SafeWork NSW

22 December 2021

COCKLE BAY WHARF MIXED USE DEVELOPMENT (SSD-9978934)

SECTION 1
1 : 100

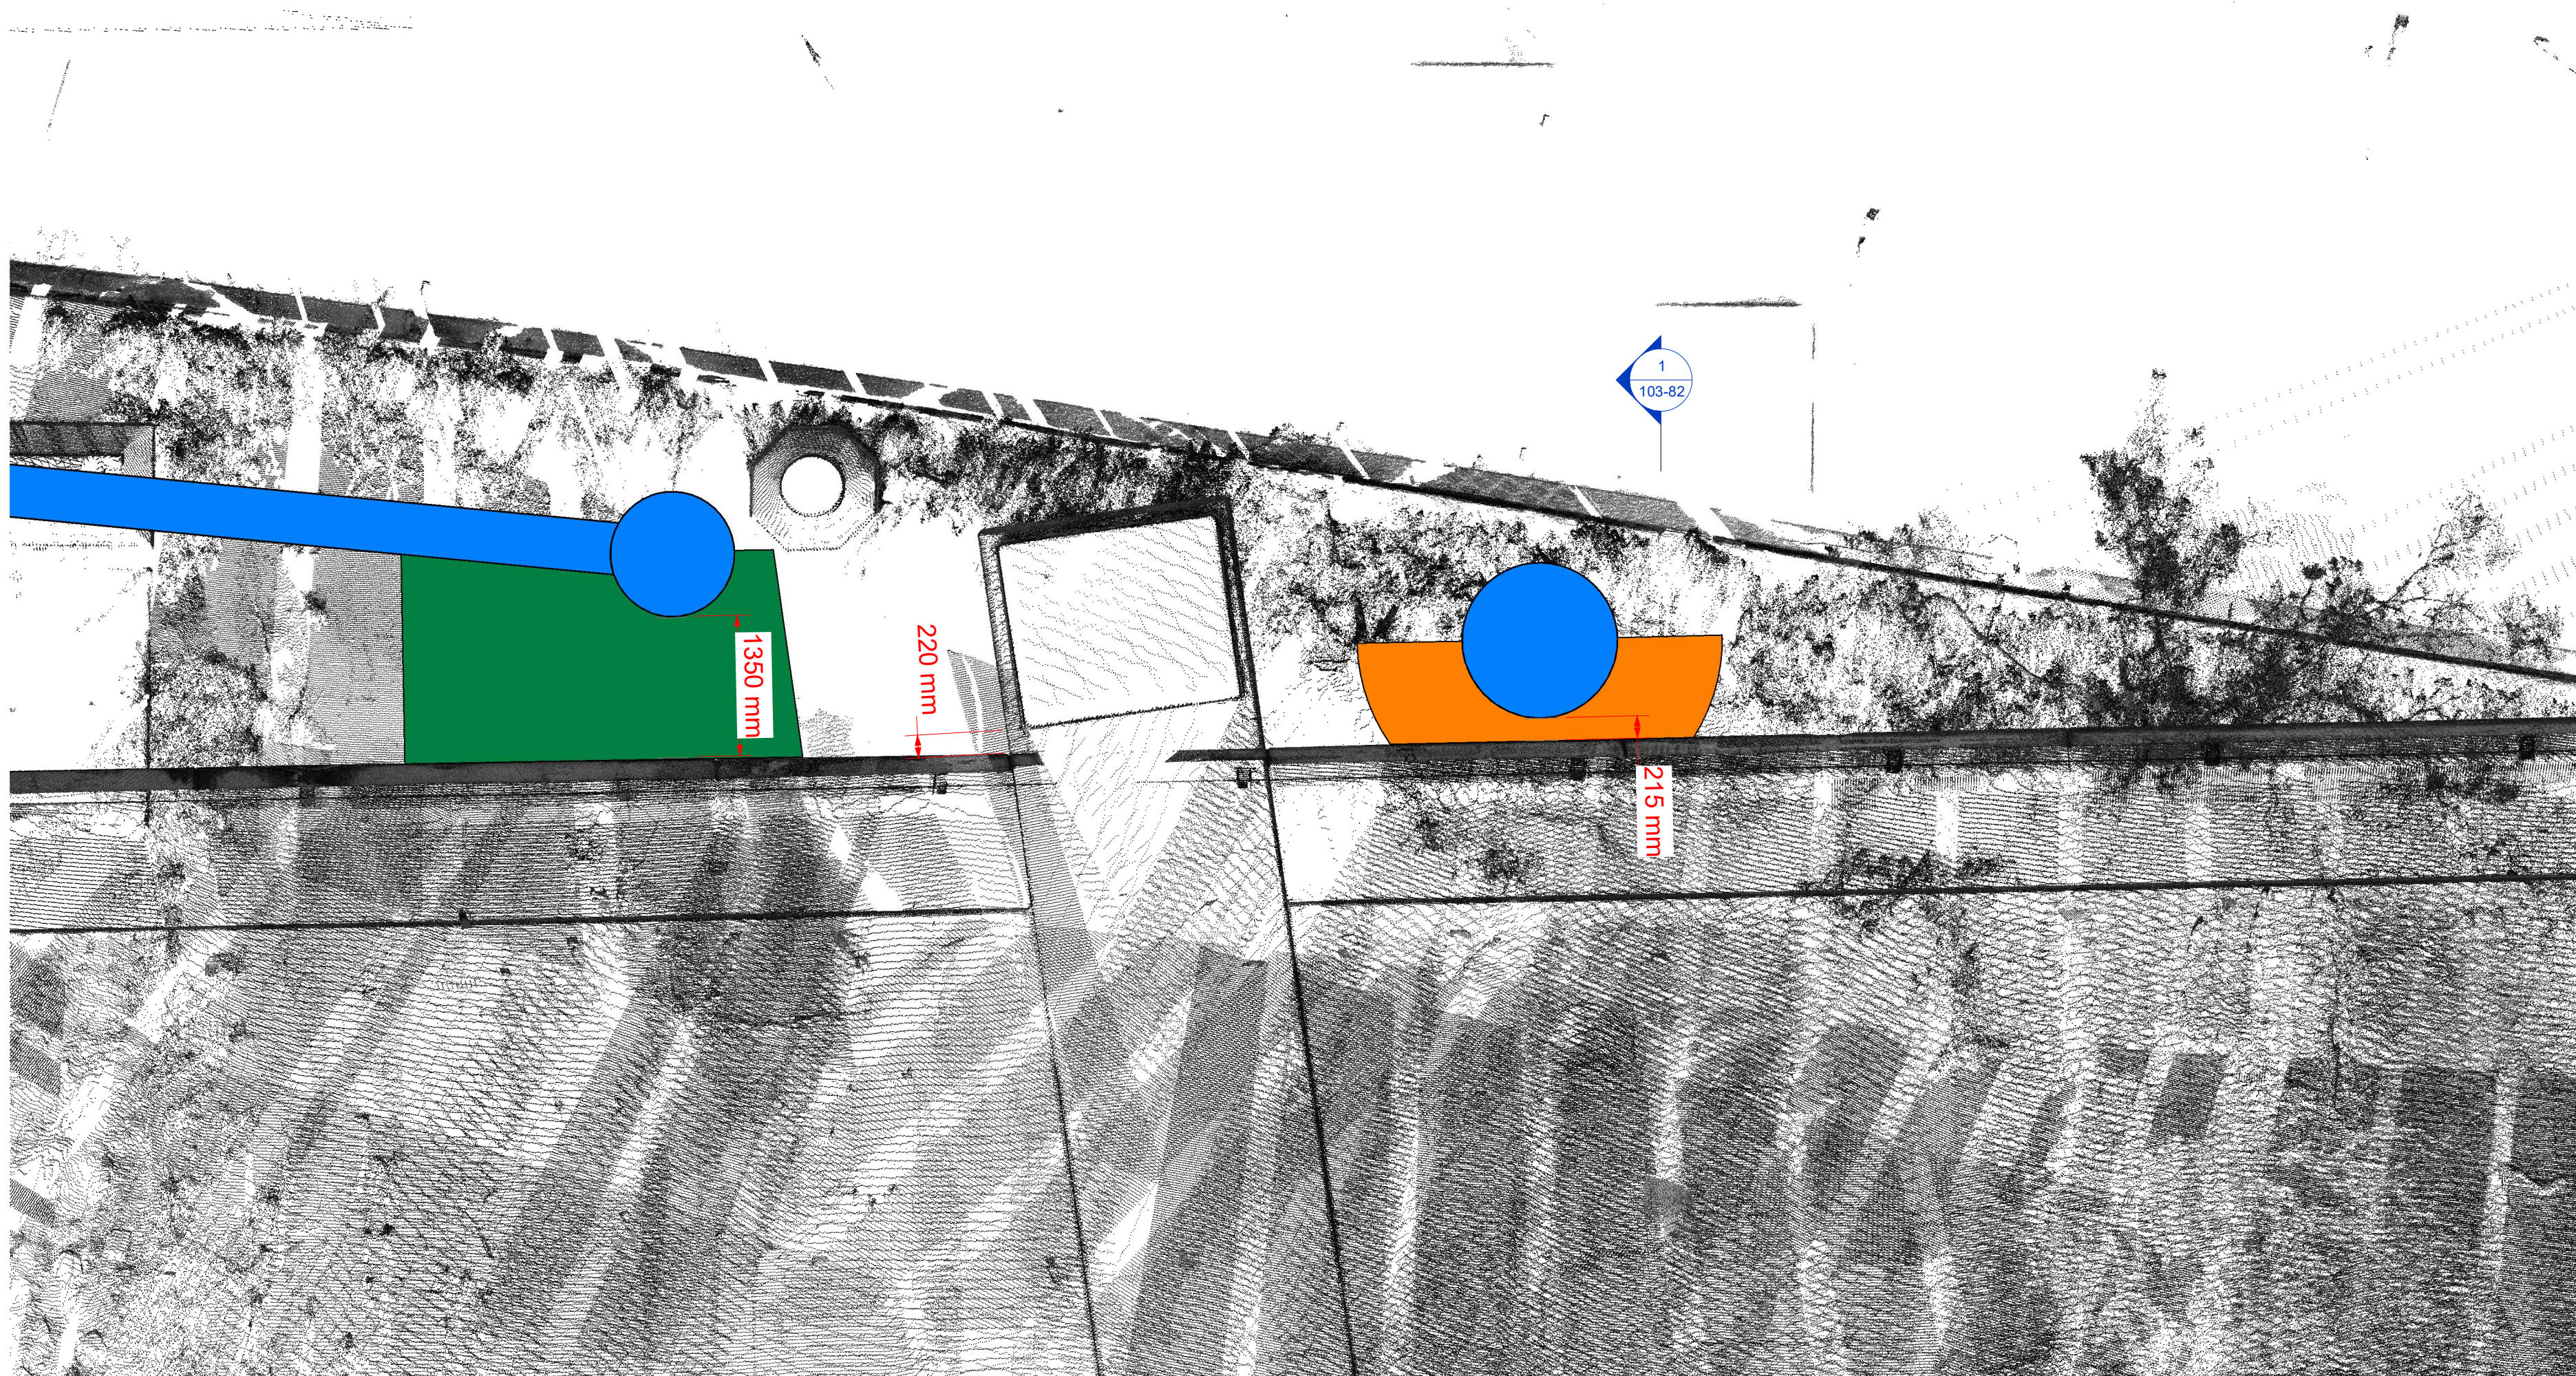
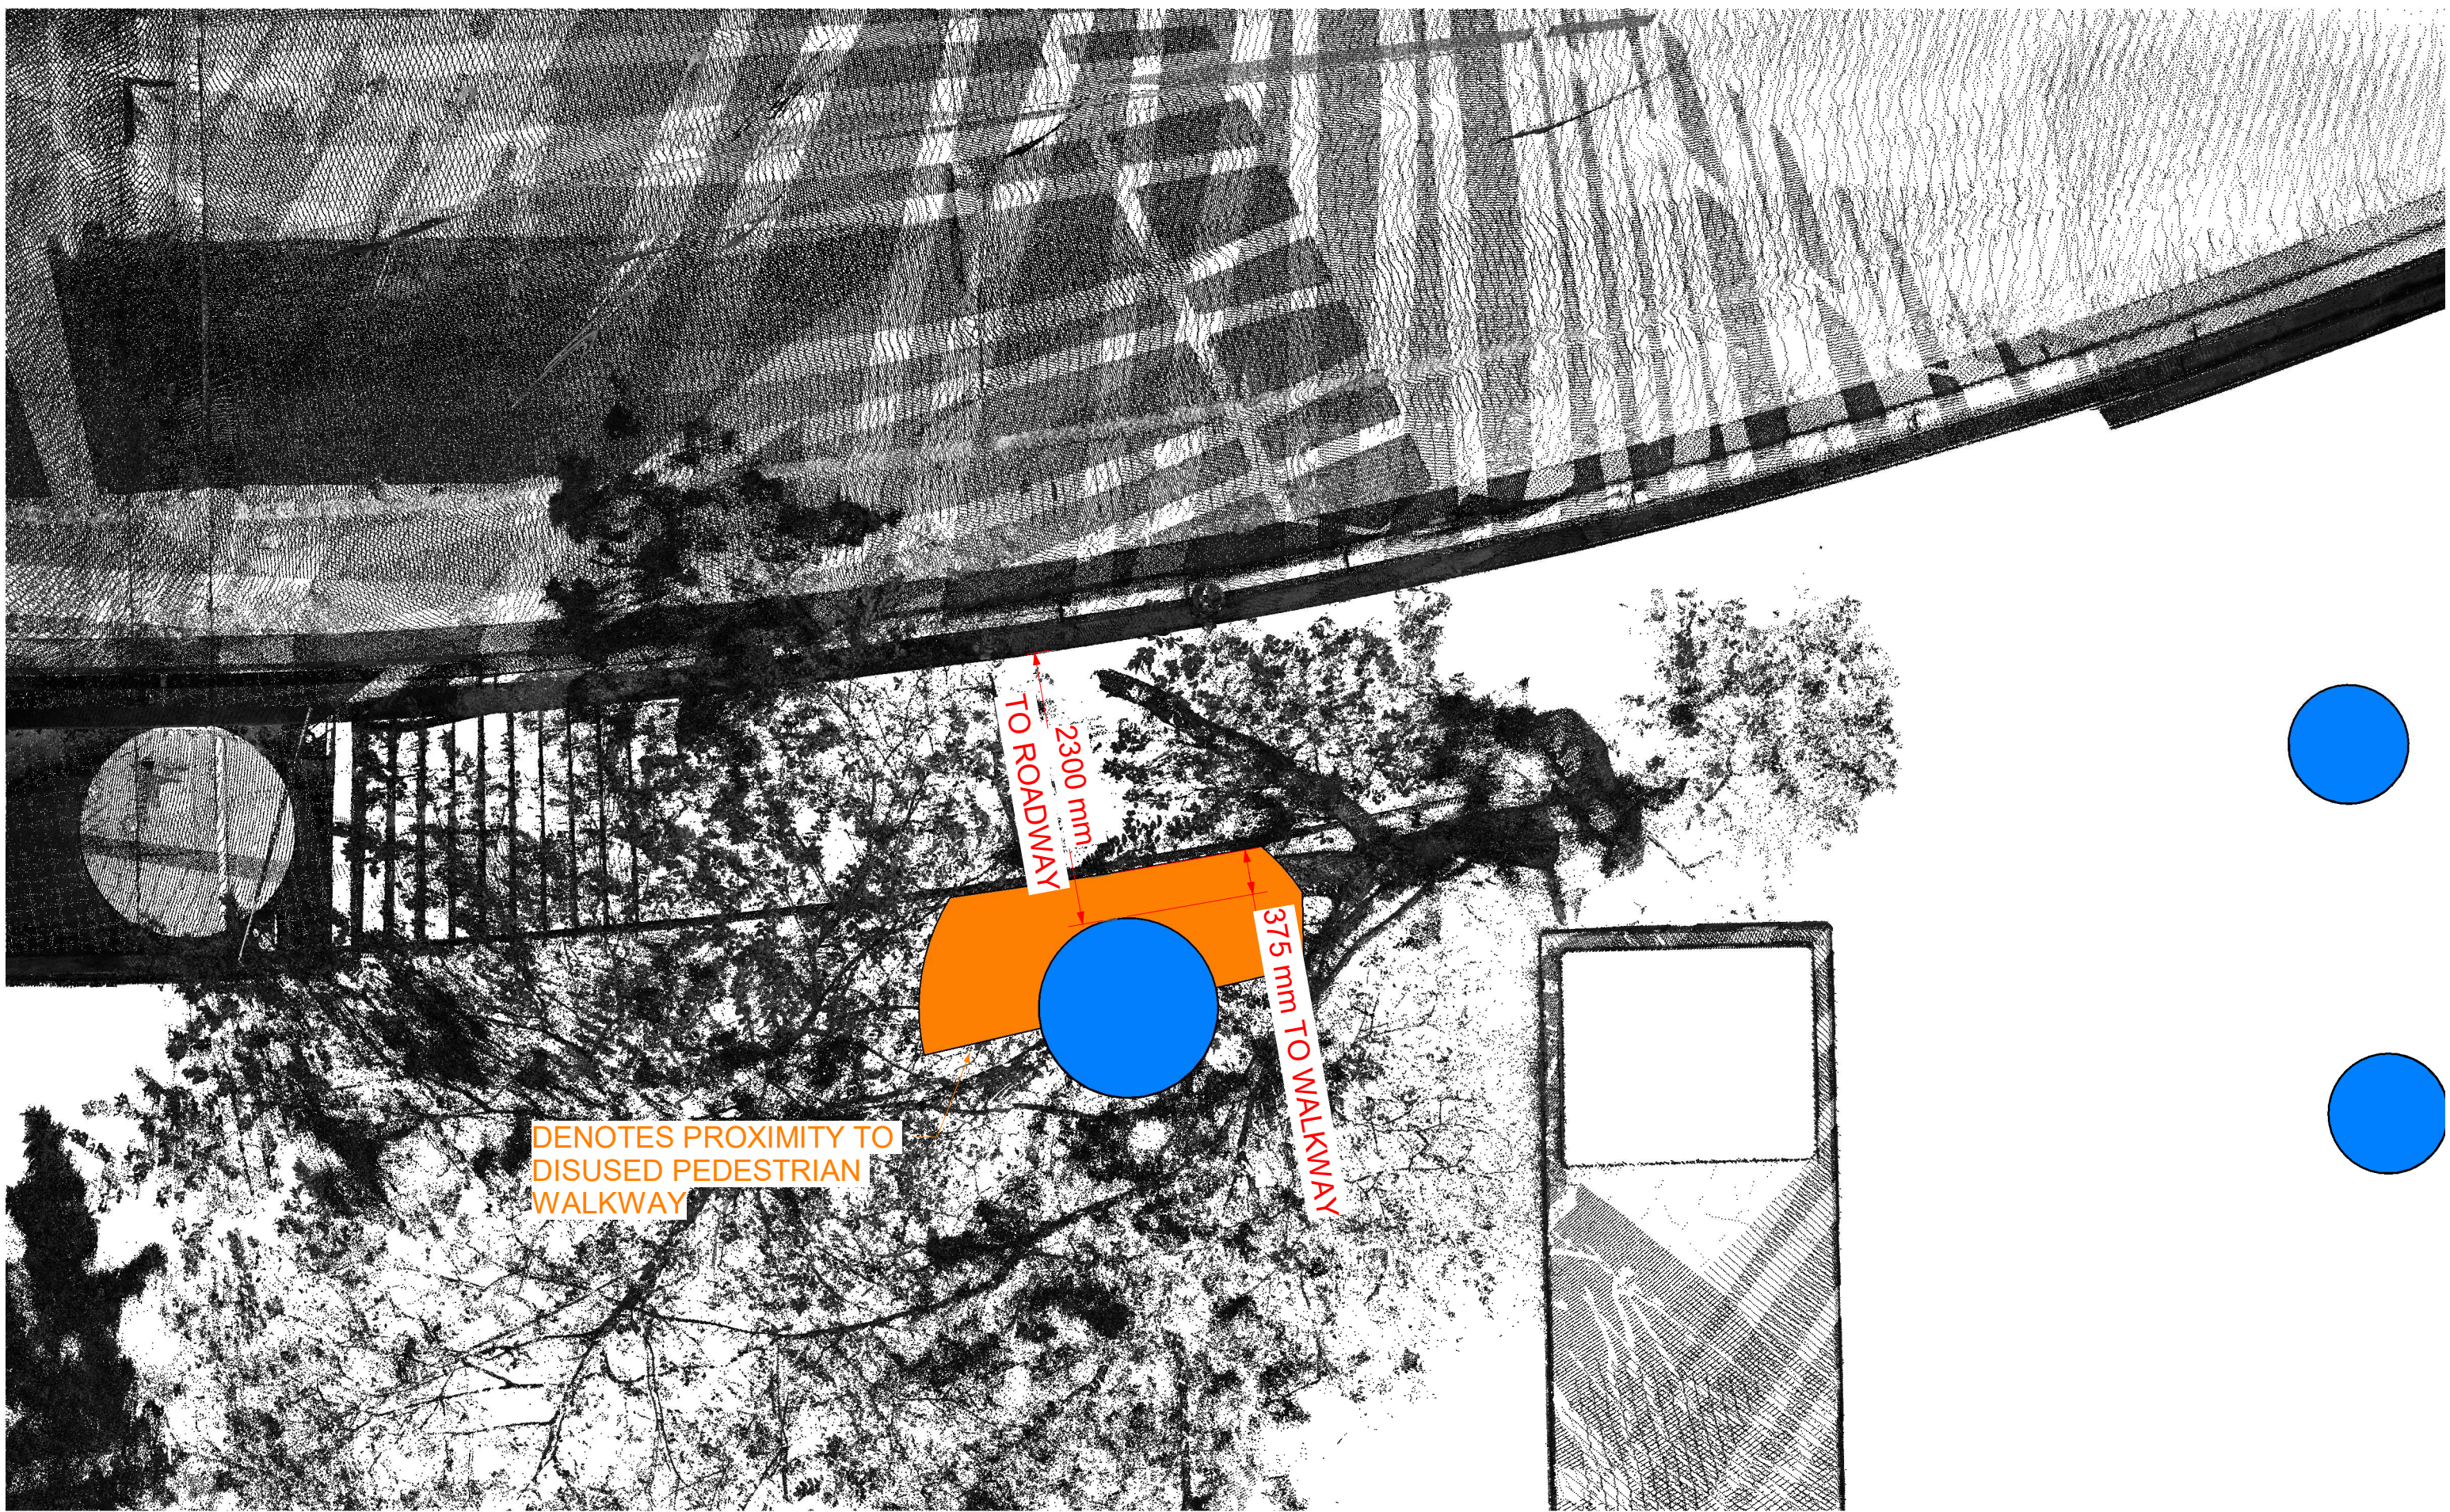
Subsequent stakeholder consultation that has been undertaken by the Applicant has been based on the premise that the enclosure of the space beneath the proposed land bridge

development does not constitute a tunnel on the premise, that the space 'is not substantially enclosed' and as such the requirements of AS 4825-2011 *Tunnel fire safety* are not required to be addressed.

A tunnel is considered within the context of this submission to be as defined within AS 4825-2011 *Tunnel fire safety* as "a substantially enclosed roadway or track-way greater than 80 metres in length." AS 4825-2011 further states that "what constitutes a tunnel depends on the likelihood of development of untenable conditions. If the degree of cover is less than 75%, the accumulation of smoke is unlikely." Given that the existing WD carriageways would be bounded by the proposed land bridge development (that is, enclosed by wall and roof structures) and that there is a resulting potential for untenable conditions, the EPA, SafeWork, and FRNSW consider this space to constitute a tunnel.

If consent is granted for the project, that DPIE consider the AS 4825-2011 definition of a tunnel in the drafting of conditions relevant to safety such as fire and life safety systems and measures that are typically afforded to modern road tunnels.
